**From:** Cialita Keys <ckey@Yakama.com>  
**Sent:** Friday, February 19, 2016 11:17 AM  
**To:** CDS User; Lindsey Ozbolt  
**Cc:** Phil Rigdon; Elizabeth Sanchey  
**Subject:** Re: Yakima River Campground CU-15-00002, SD-15-00001, SP-15-00001  
**Attachments:** Yakima River Campground\_2\_17\_16.pdf

RE: Yakima River Campground - CU-15-00002, SD-15-00001, SP-15-00001

TO: Phil Rigdon, Deputy Director, DNR  
THROUGH: Scott Nicolai, Yakima Subbasin Habitat Coordinator, YKFP  
FROM: John Marvin, Habitat Biologist, YKFP  
DATE: Wednesday February 17, 2016  
RE: CU-15-00002 Yakima River Campground

YAKIMA RIVER SHORT PLAT - SP 15-XXXXX
 A PORTION OF THE NORTH 1/2 OF SECTION 4,
 TOWNSHIP 19 NORTH, RANGE 16 EAST, W.M.,
 KITTITAS COUNTY, WASHINGTON

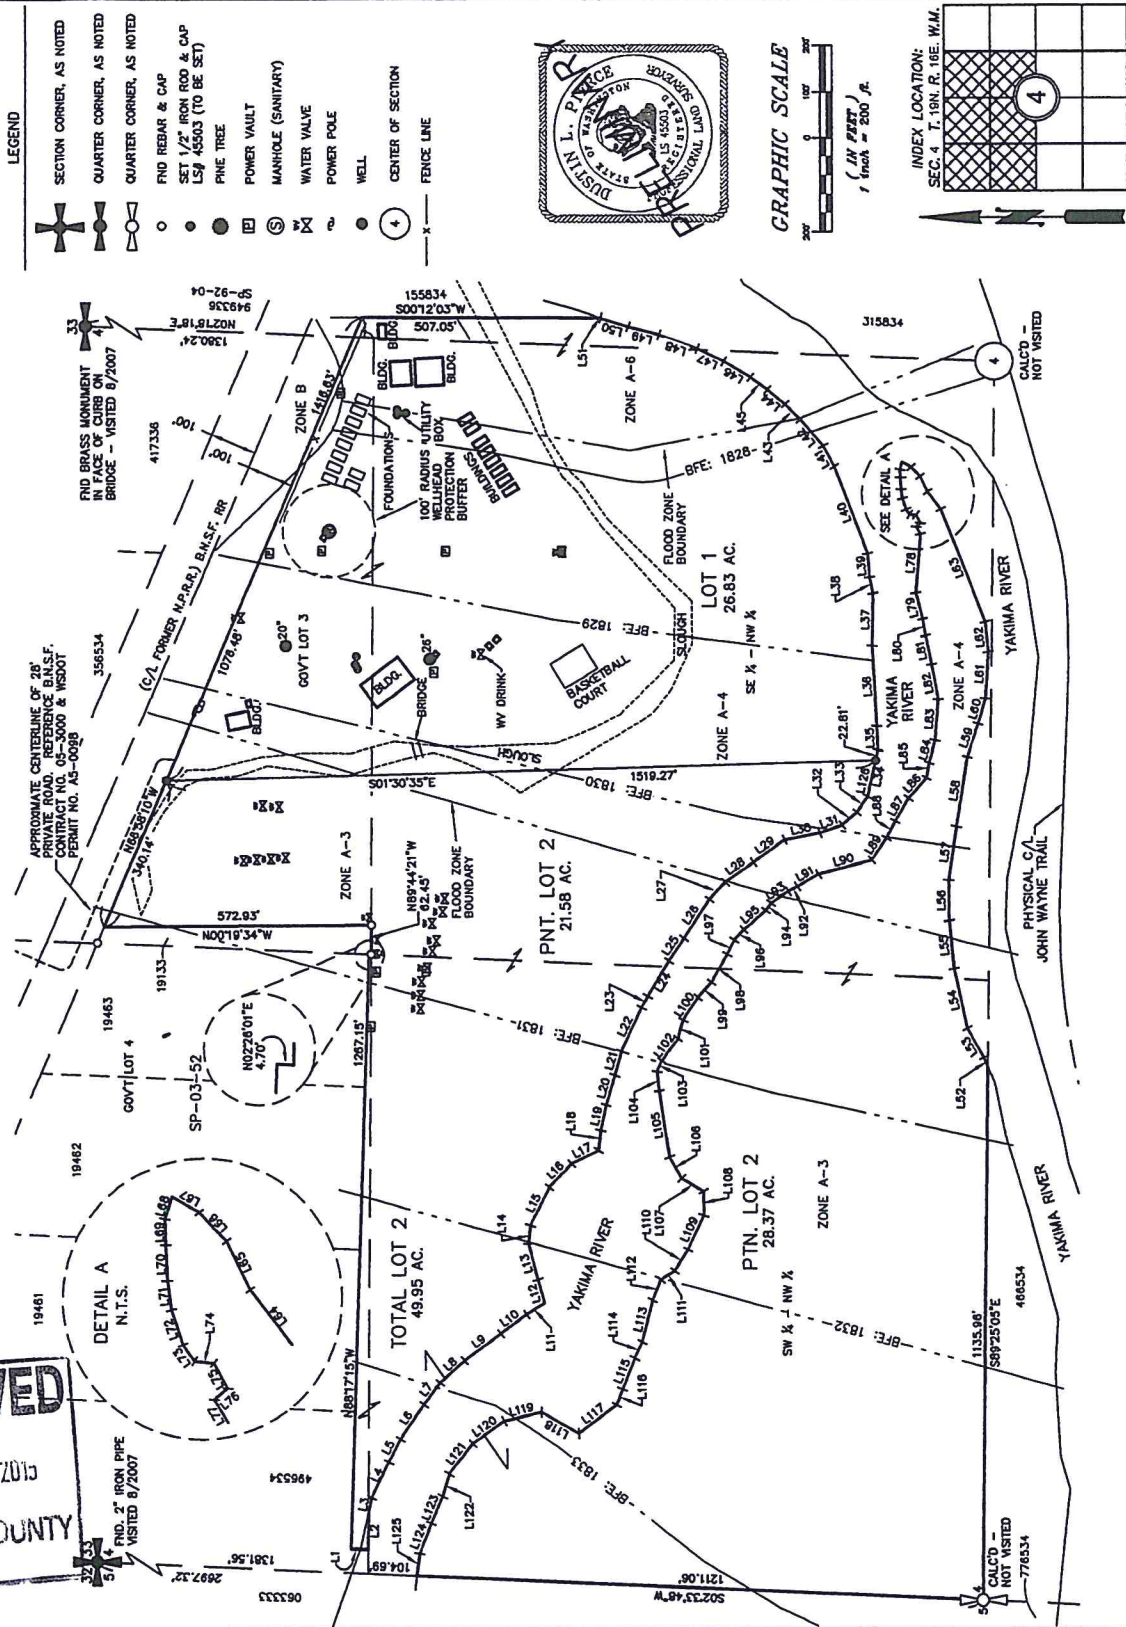
The site plan in the file indicates that a boat launch is proposed, yet there is no discussion of the boat launch in the project description or in the SEPA checklist. It is therefore assumed that a boat launch is not included in the proposal. The site plan also depicts an "existing road" through the floodway to the Yakima River. There should be no road there. The original approval of the camp was conditioned on leaving the floodway in its natural state as mitigation, no vehicles were to be allowed in this area. If there is an old road in this area it should be considered abandoned.

- 1) Deny development in the floodway without the inclusion of additional EIS analysis and mitigation.
- 2) Specifically exclude the boat launch from final approval, unless additional information is provided and the comment period re-notified.
- 3) Required buffers should be the maximum allowed by KCC 17A and the Kittitas Shoreline Master Program. Any critical areas/Shoreline functions and values impacted by the project should be fully mitigated accordingly, including, but not limited to requiring buffers to be restored with native vegetation as mitigation for increased impact by the proposed development.
